WEST SUSSEX COUNTY COUNCIL CONSULTATION

TO:	Arun District Council FAO: David Easton
FROM:	WSCC - Highways Authority
DATE:	23 April 2019
LOCATION:	Land north of Hook Lane, Pagham
SUBJECT:	P/30/19/OUT Outline application with some matters reserved for the construction of up to 300 No. new homes, a care home of up to 80 beds, D1 uses of up to 4,000 sqm including a 2 form entry primary school, the formation of new means of access onto Hook Lane & Pagham Road, new pedestrian & cycle links, laying out of open space, new strategic landscaping, habitat creation, drainage features & associated ground works & infrastructure. This application may affect the setting of a listed building & is a Departure from the Development Plan (resubmission following P/6/17/OUT).
DATE OF SITE VISIT:	As part of P/6/17
RECOMMENDATION:	More Information
S106 CONTRIBUTION TOTAL:	£ See below for breakdown.

NOTES:
 Reproduced by Stanfords by permission of Ordnance Survey®
 on behalf of the Controller of Her Majesty's Stationery Office.
 © Crown copyright and database rights 2016 OS Licence
 100035409.

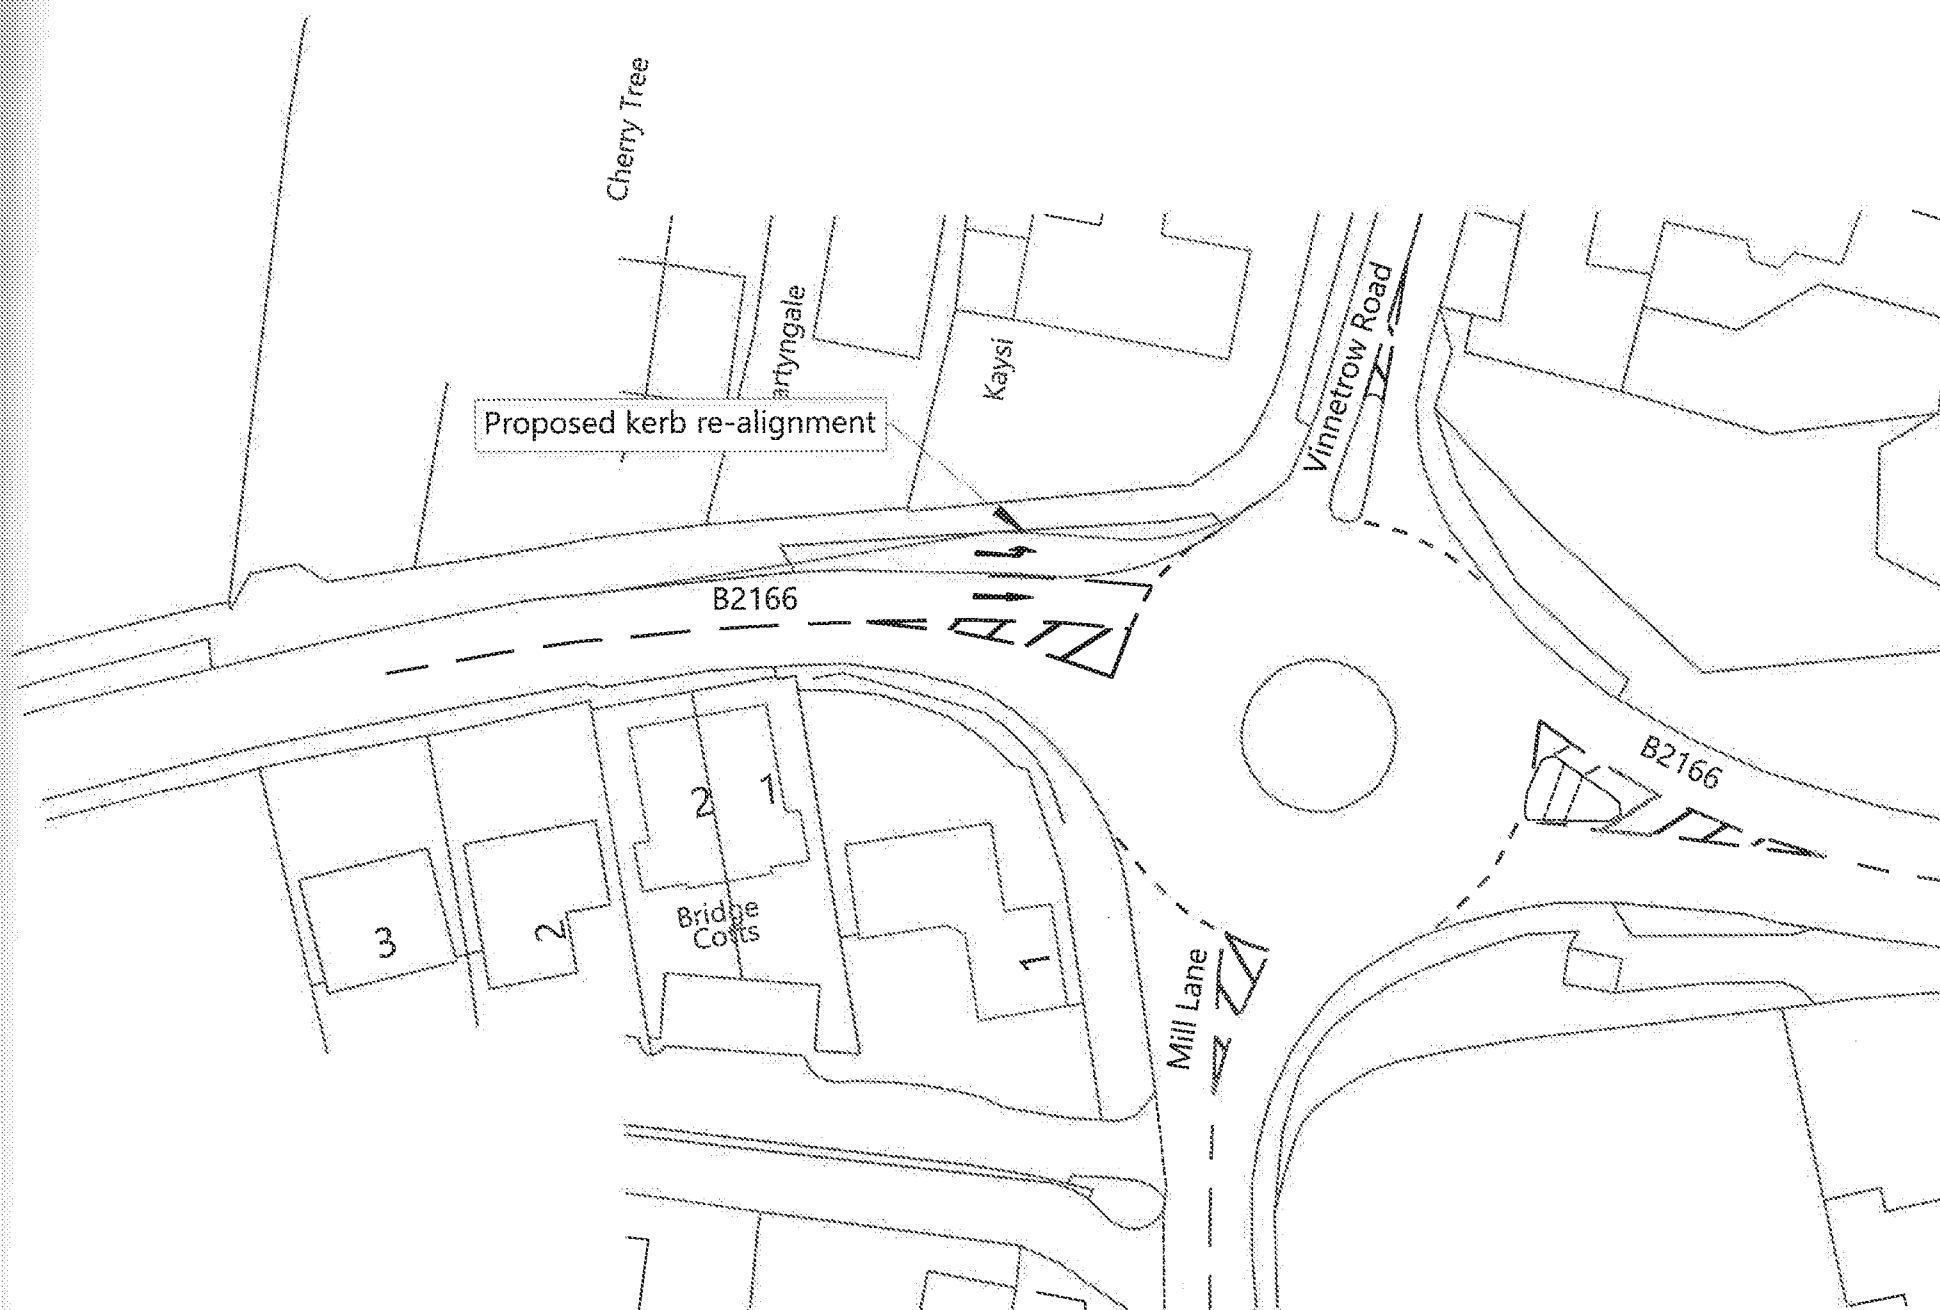
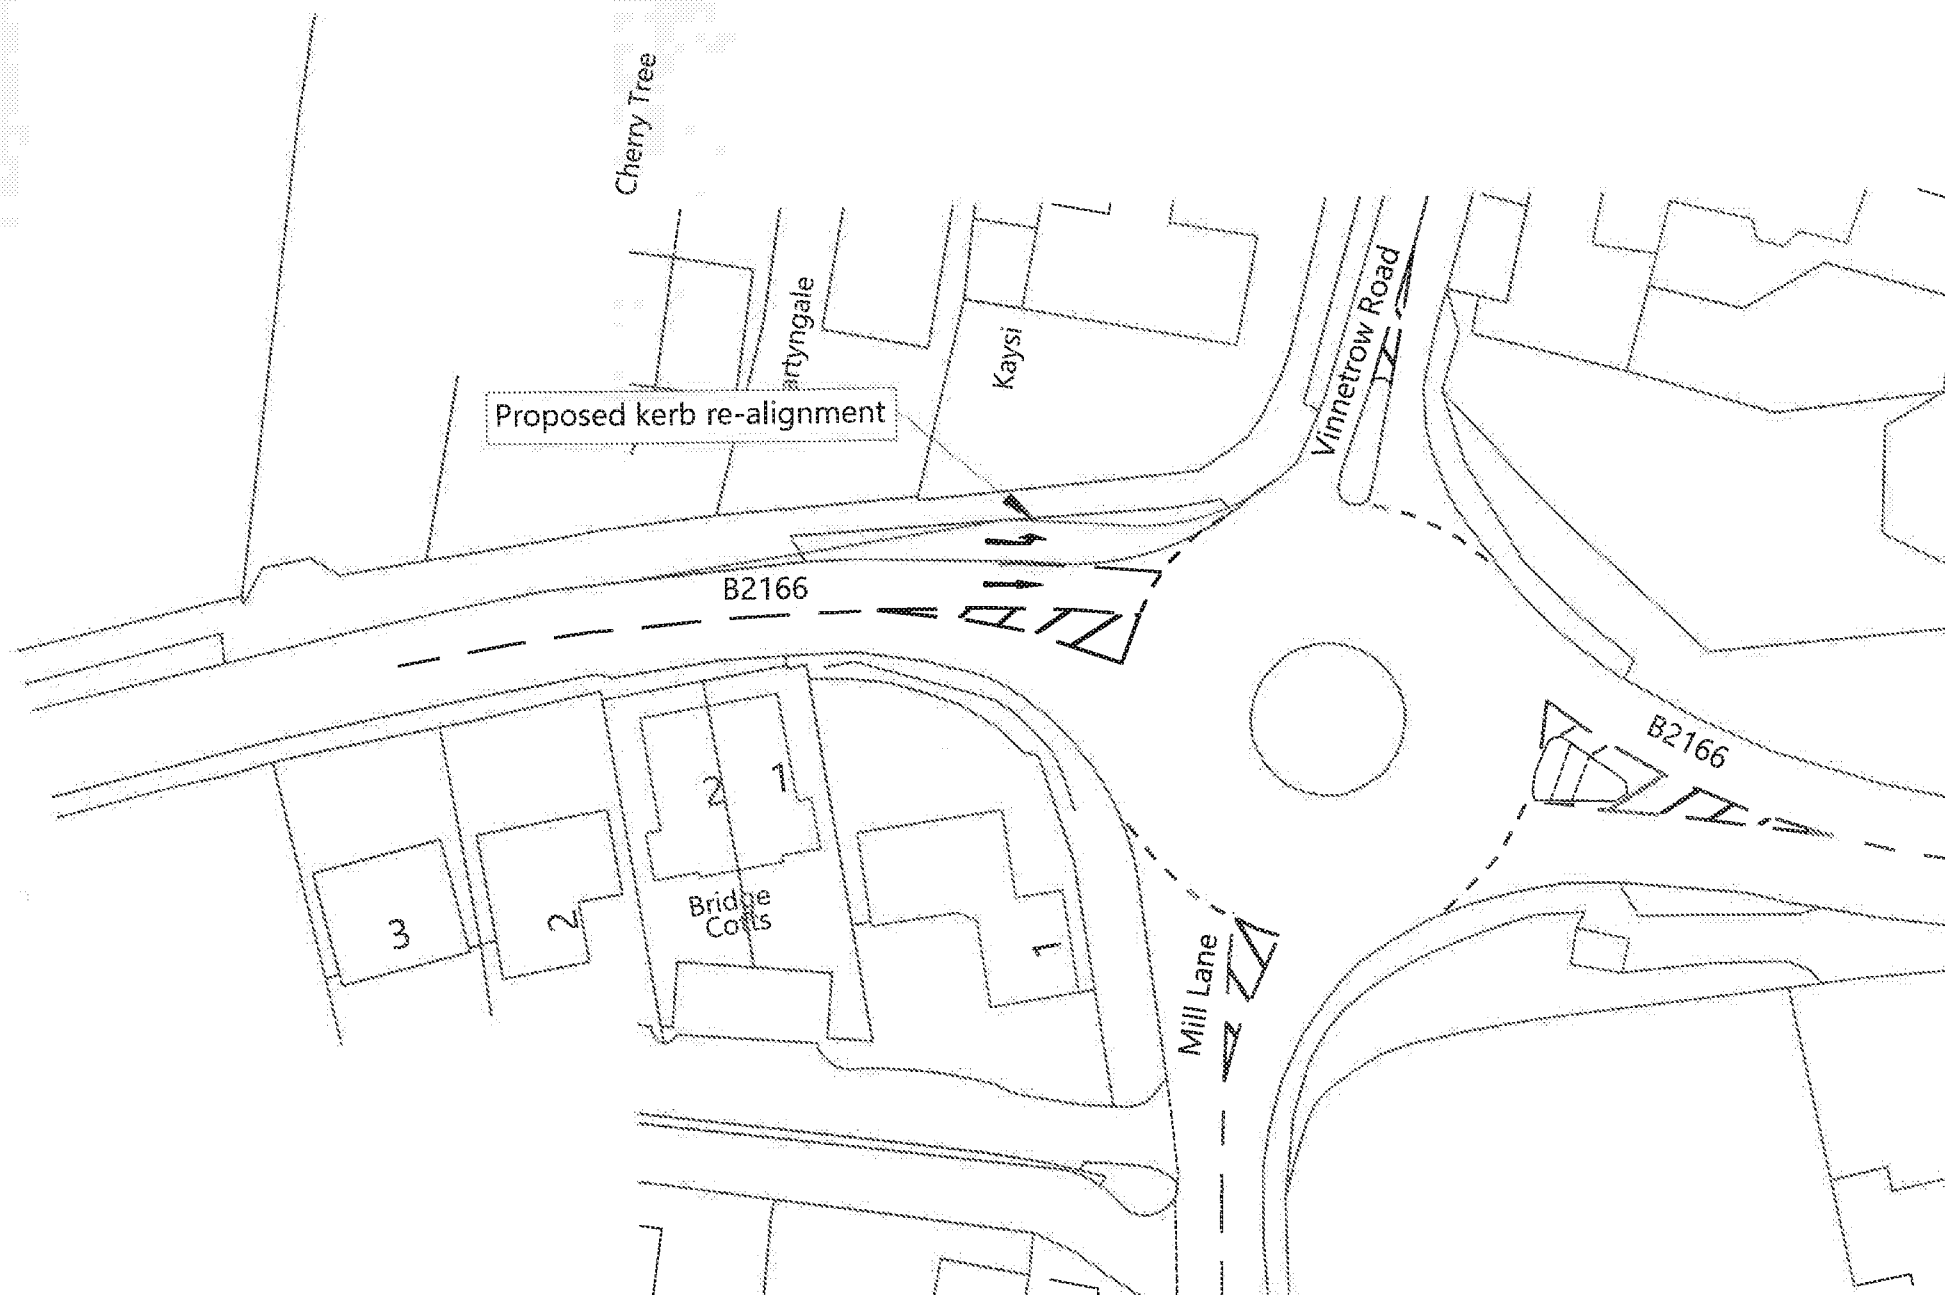
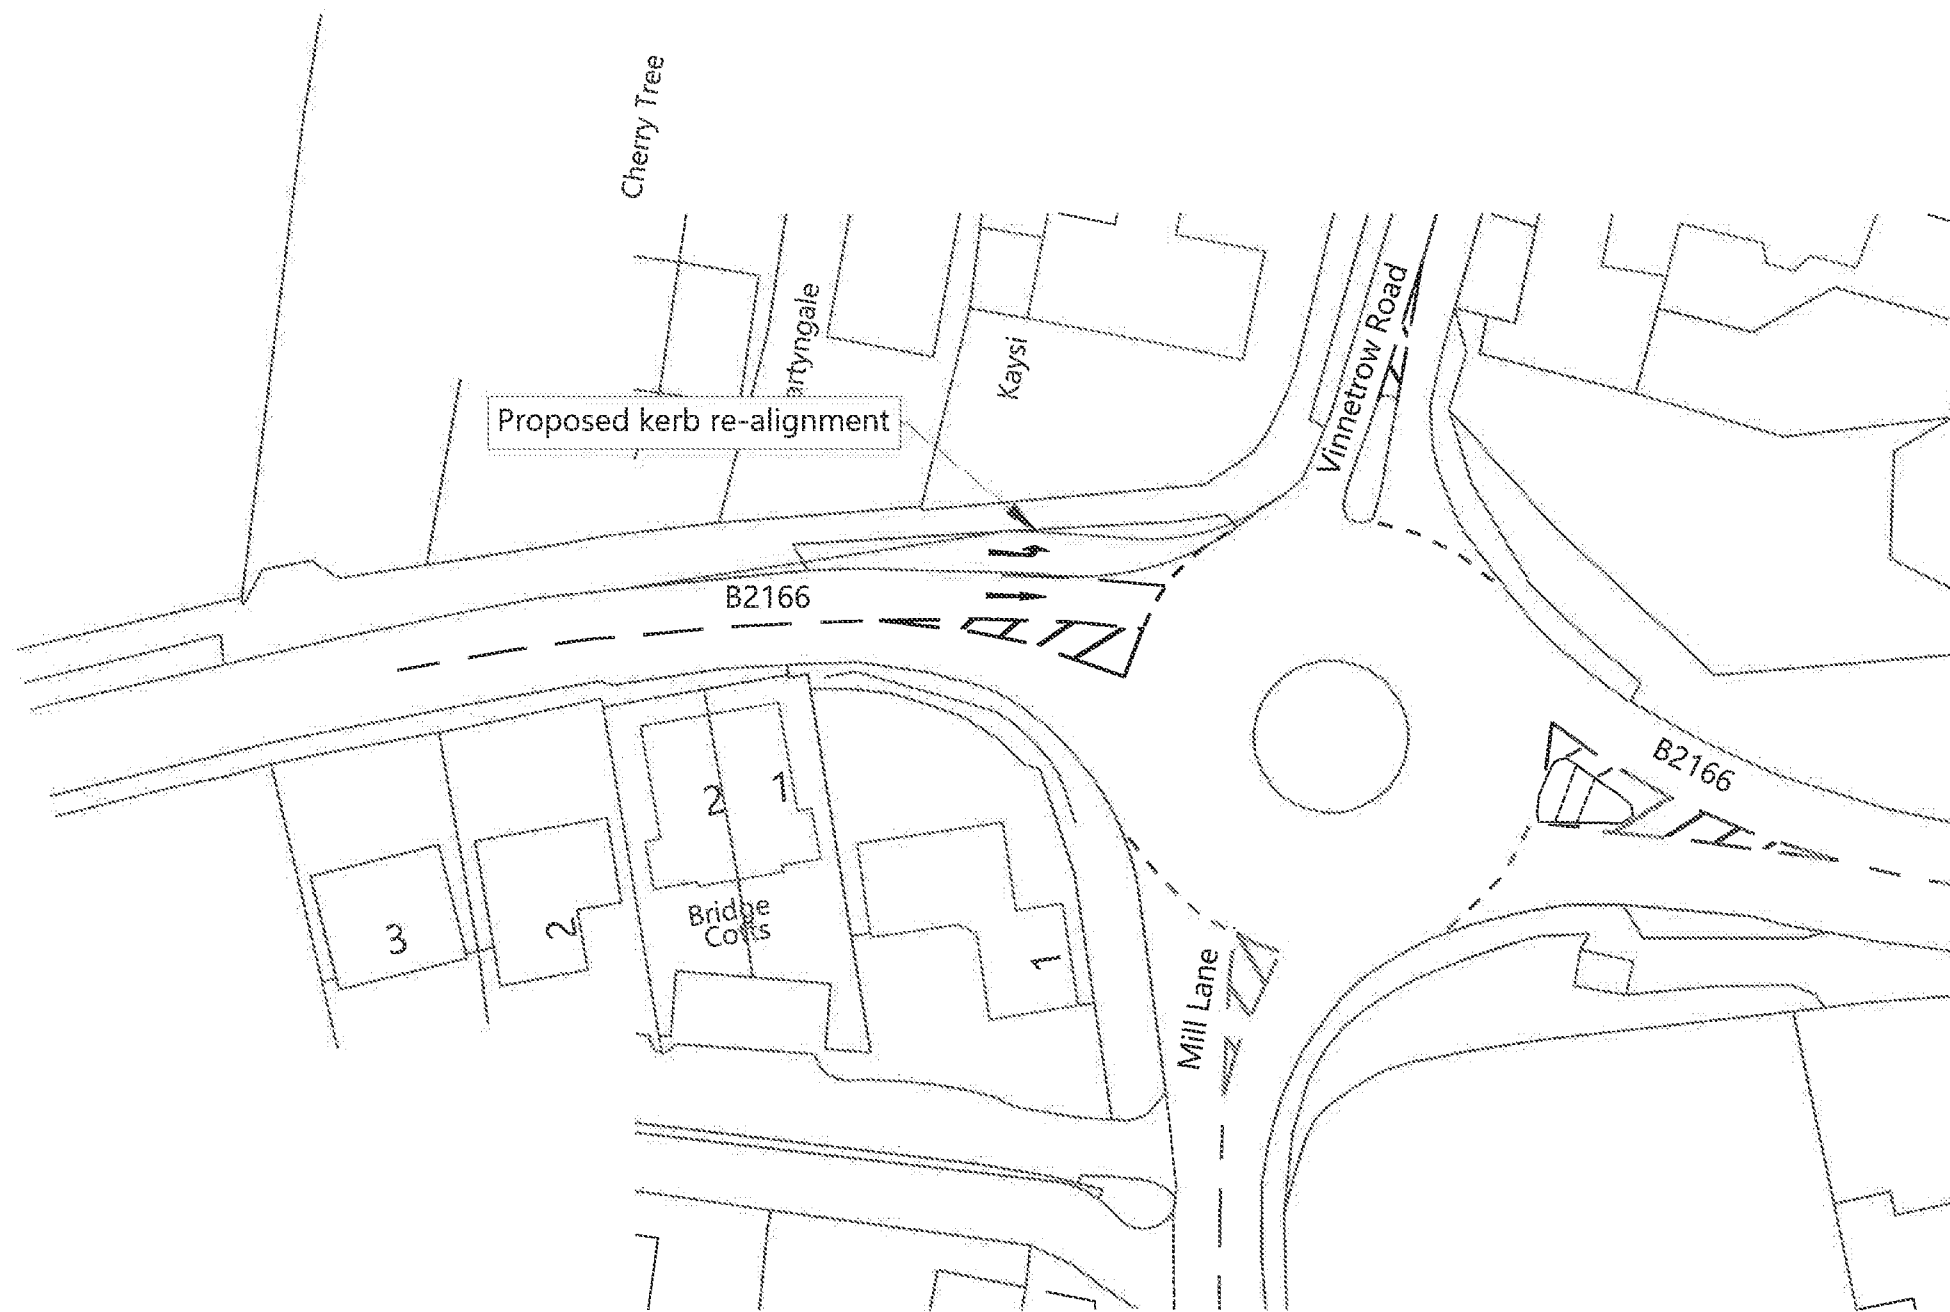
3. The development is to take vehicular access from Pagham Road and Hook Lane. All accesses are to take the form of simple priority junctions. Two accesses are to be provided on Hook Lane with a further single access onto Pagham Road. This arrangement reflects that submitted initially with P/6/17.
4. Whilst there is no objection to the three accesses, there appears scope to rationalise and remove the more southerly Hook Lane access; this access was removed as part of P/6/17. This access is unlikely to be used by any significant volume of traffic in light of the location of the northerly Hook Lane and Pagham Road accesses. It would be requested for consideration to be given to reducing the number of access points onto Hook Lane.

6. In checking the stopping sight distances at the two Hook Lane accesses against the recorded speeds, the sightlines appear to exceed those typically required using MfS Stopping Sight Distances. On this basis, the LHA are satisfied that adequate visibility can be achieved onto Hook Lane within land forming part of the adopted highway and/or land under the control of the applicant. The geometry in all other respects appears acceptable and complies with current guidance.

8. Based on the recorded 85th percentile speeds and the DMRB, SSDs of 152 metres to the south and 149 metres to the north are required. These are demonstrated from an X distance of 4.5 metres. The distances are considered acceptable and can be achieved within land forming part of the adopted highway and/or under the control of the applicant.

9. The vehicle access arrangements have been reviewed by way of a Stage One Road Safety Audit. Whilst appreciated that the Audit was accepted previously, the standards on which RSAs are undertaken has been updated. The Audit should be updated so as to comply with the latest RSA standards.
